Re: Hollywood Video, 160 Preble Street; 2003-0233; CBL 034-K-001

This letter is to confirm that the Portland Planning Authority has reviewed and approved certain revisions to the building façade elevation for the Hollywood Video Store located at 160 Preble Street. The approval is subject to the following conditions:

# NORTH EXTERIOR ELEVATION

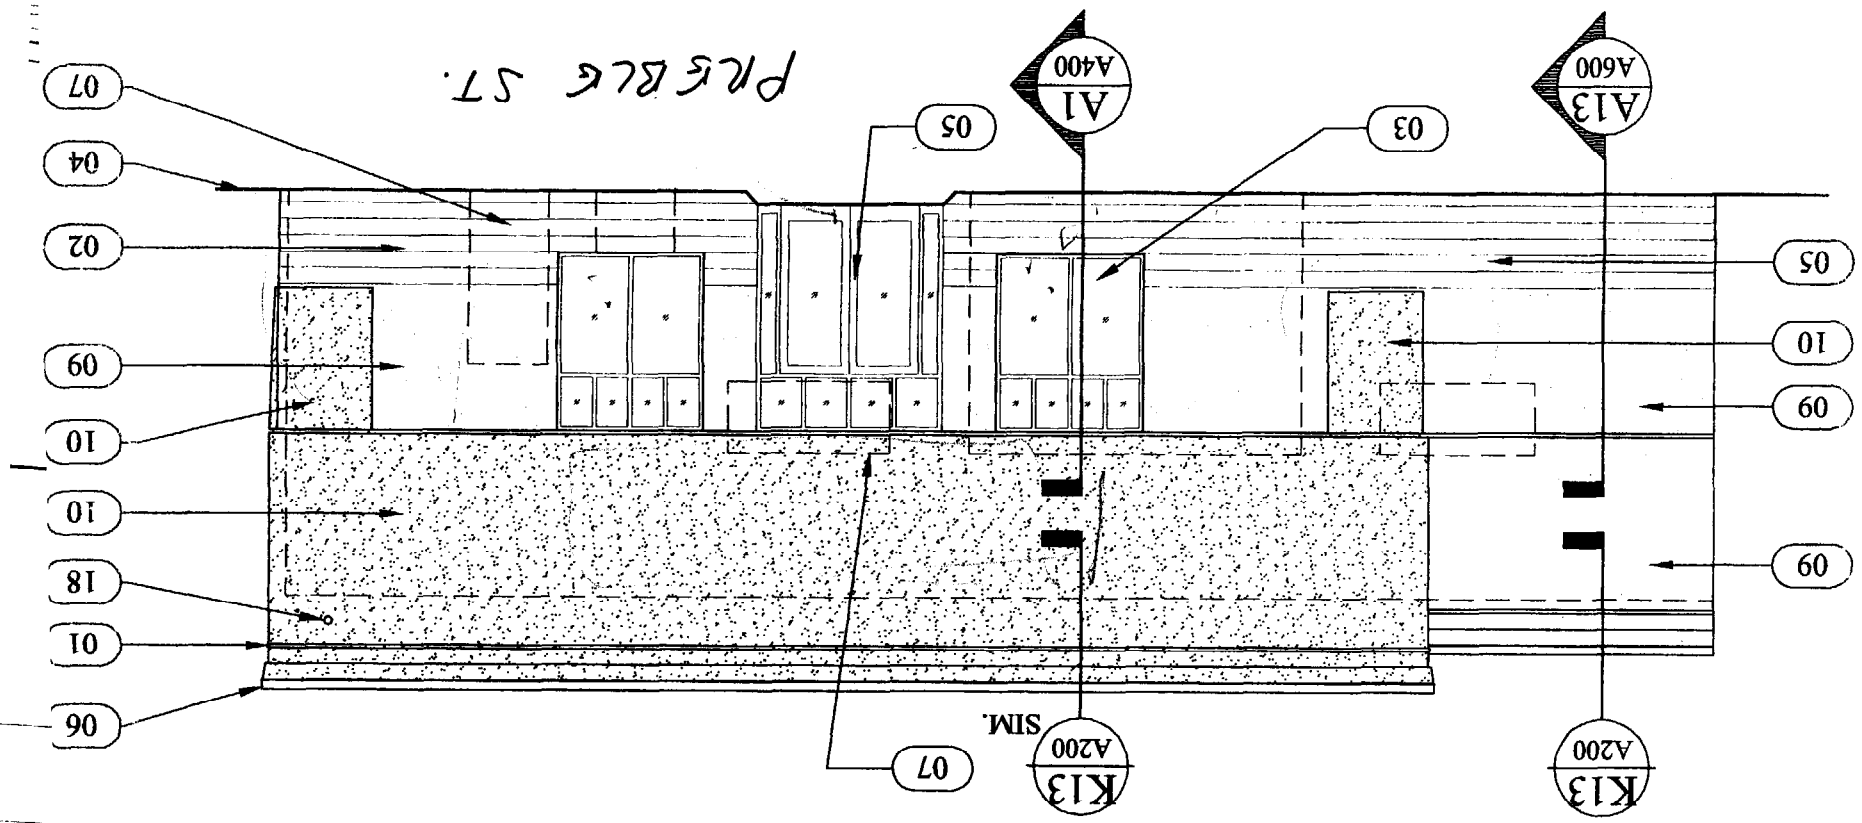
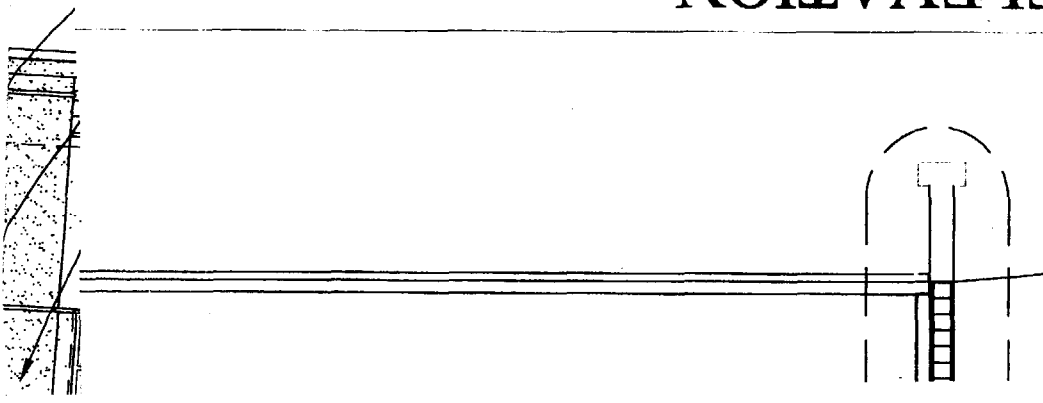
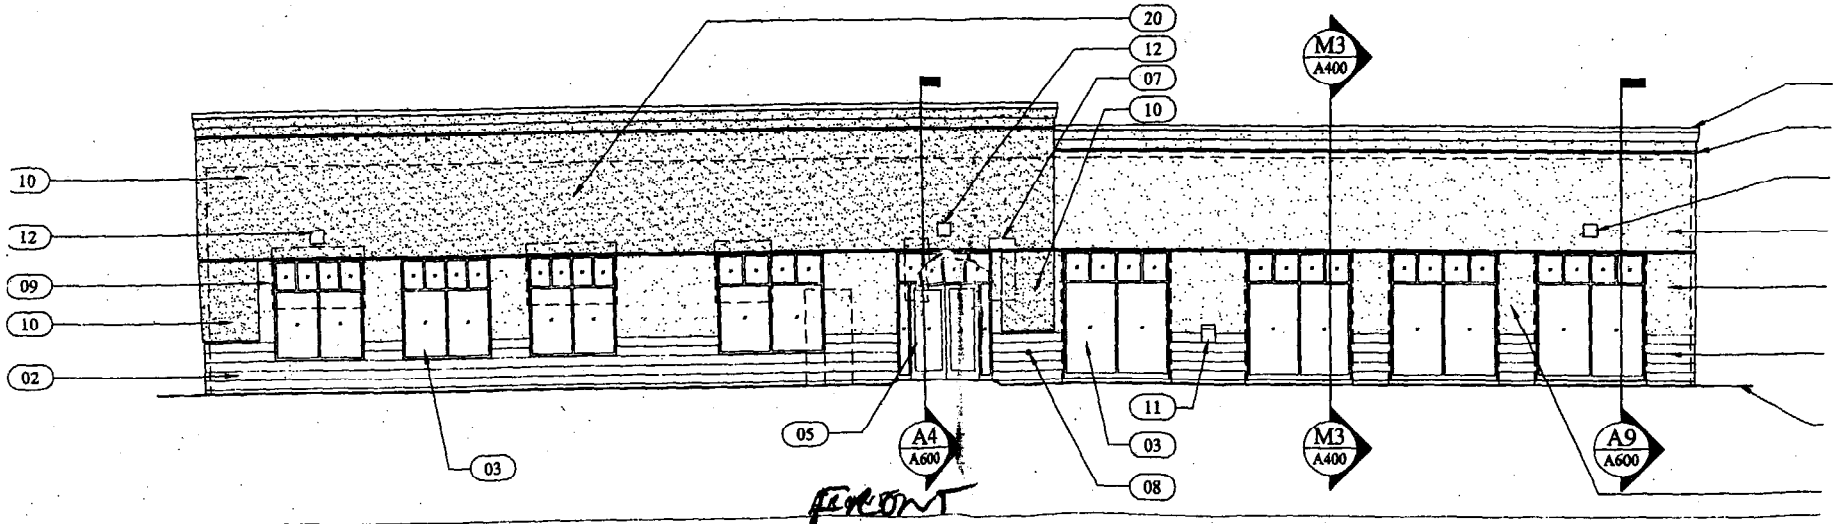
1. That the Preble Street doorway shall be functional and open as a customer entrance for ingress and egress.
2. That the uplighting shall be removed from the plan and that the lighting specifications on the remaining light fixtures on the building shall be submitted for Planning Staff review and approval.
